**Planning Department
Transportation Development Services**

**Re: Range Cafe
1050 Rio Grande NW
Traffic Circulation Layout
Engineer's/Architect's Stamp dated 1-5-16 (H13-D029)**

Based upon the information provided in your submittal received 1-5-16-15, the above referenced plan cannot be approved for Building Permit until the following comments are addressed:

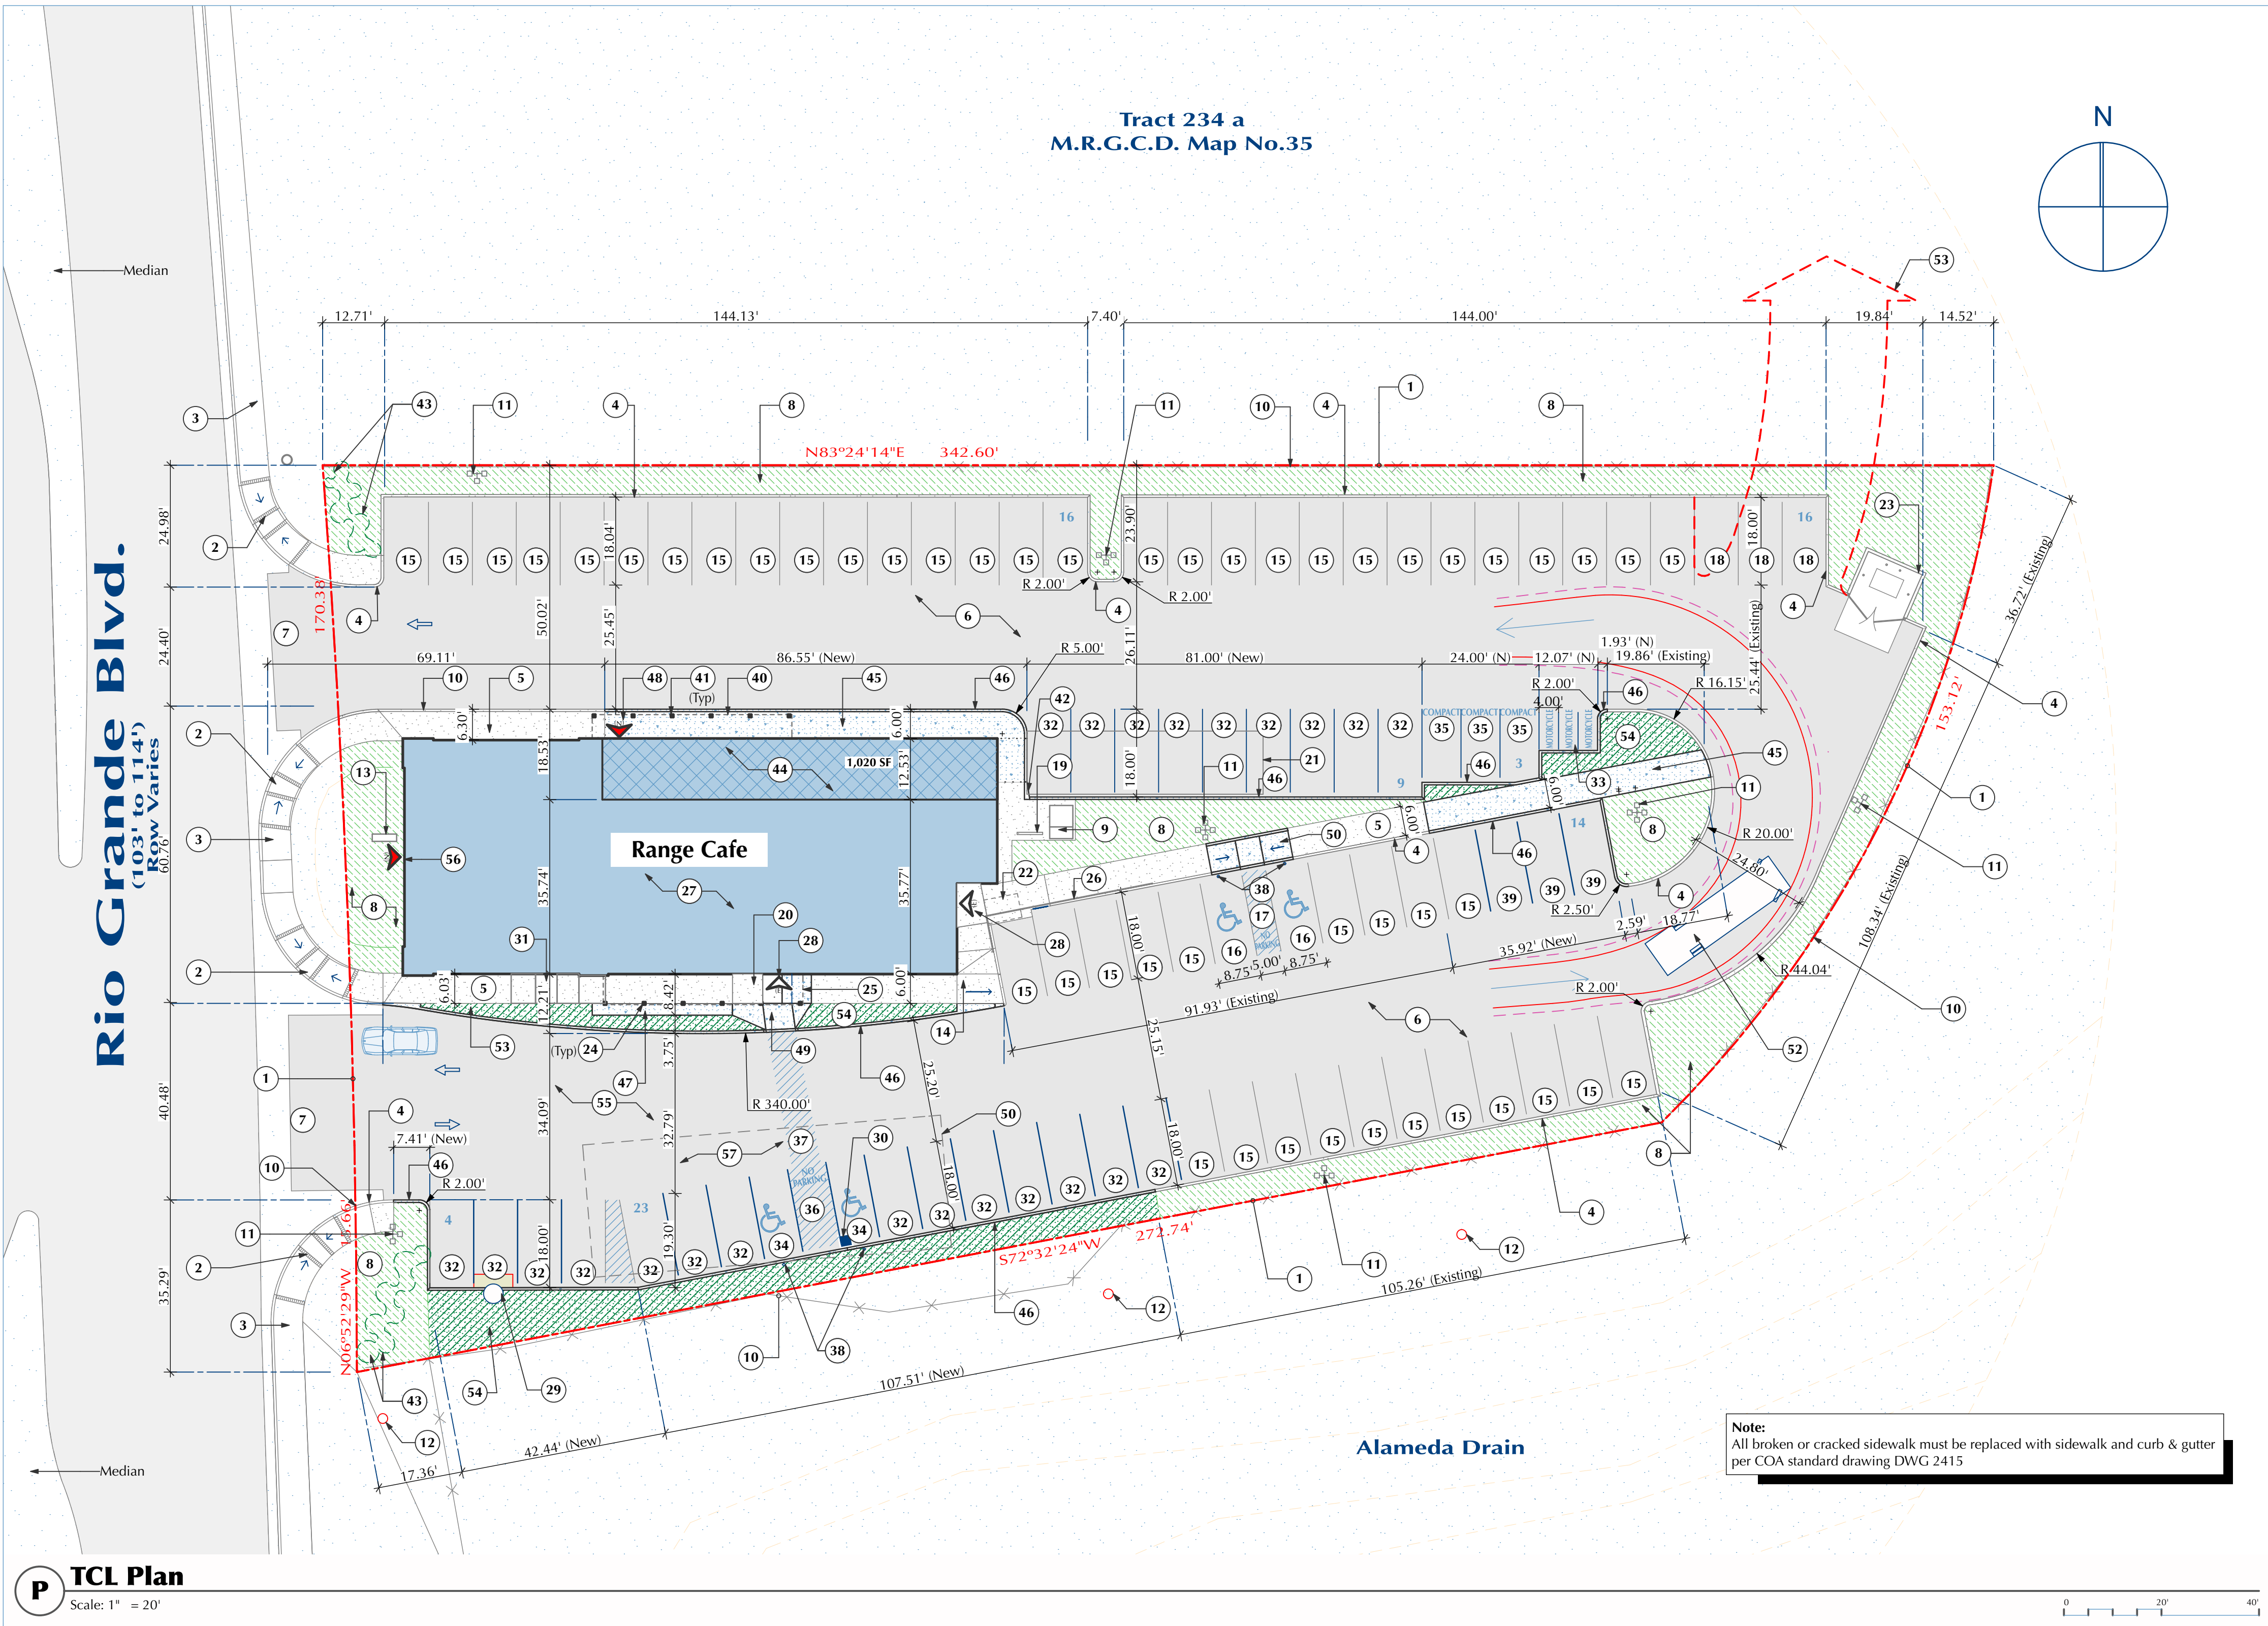
1. Please show a vicinity map showing the location of the development in relation to streets and well known landmarks.
2. Please detail and dimension all existing sidewalks, curb ramps and curb cuts on Rio Grande Blvd. to ensure compliance to ADA standards. Detail "S" on drawing refers to curb ramp on ADA access isle. Key Notes #2, 3 and 7 do not give dimension to existing northern entrance/exit, sidewalk and ramps.

3. Please dimension existing sidewalk along building. Detail "E" shows a dimension of 6 ft. for the sidewalk at the ADA access point. Please clarify width of entire sidewalk. Key Note #5 does not give a dimension.

4. The handicap accessible spaces must include an 8-foot wide van access aisle; all other aisles should be 5 feet in width. The ADA parking access isle along the building's south entrance is only shown to be 5 ft. wide, Key Note #17 calls out dimension of 8 Ft. Please clarify dimension of access isle. Also, Key Note #16 does not call out a dimension for the existing ADA parking space.

5. Please call out the distance between abutting parking spaces on the south side of building.
6. Per the DPM, a 6 ft. wide ADA accessible pedestrian pathway is required from the HC parking stall access aisles to the building entrances. Please clearly show and dimension side walk width. Key Note #5 does not give a dimension.

7. Please provide a sight distance exhibit (see the *Development Process Manual, Chapter 23, Section 3, Part D.5 Intersection Sight Distance*). Please show this detail for both entrances from Rio Grande Blvd. Detail "O" and "T" both detail the Clear Sight for the northern entrance.

8. Please add the following note to the clear sight triangle: "Landscaping and signage will not interfere with clear sight requirements. Therefore, signs, walls, trees, and shrubbery between 3 and 8 feet tall (as measured from the gutter pan) will not be acceptable in this area." This note must be on the drawing.
9. Future Drive Cut Key (Note #52) will require an easement and access agreement with adjacent property owner. Parking space will not be allowed in this easement area and must be subtracted from parking space calculations.
10. Please include a copy of your shared access agreement with the adjacent property owner.
11. All broken or cracked sidewalk must be replaced with sidewalk and curb & gutter. A build note must be provided referring to the appropriate City Standard drawing.
12. Please include two copies of the traffic circulation layout at the next submittal.
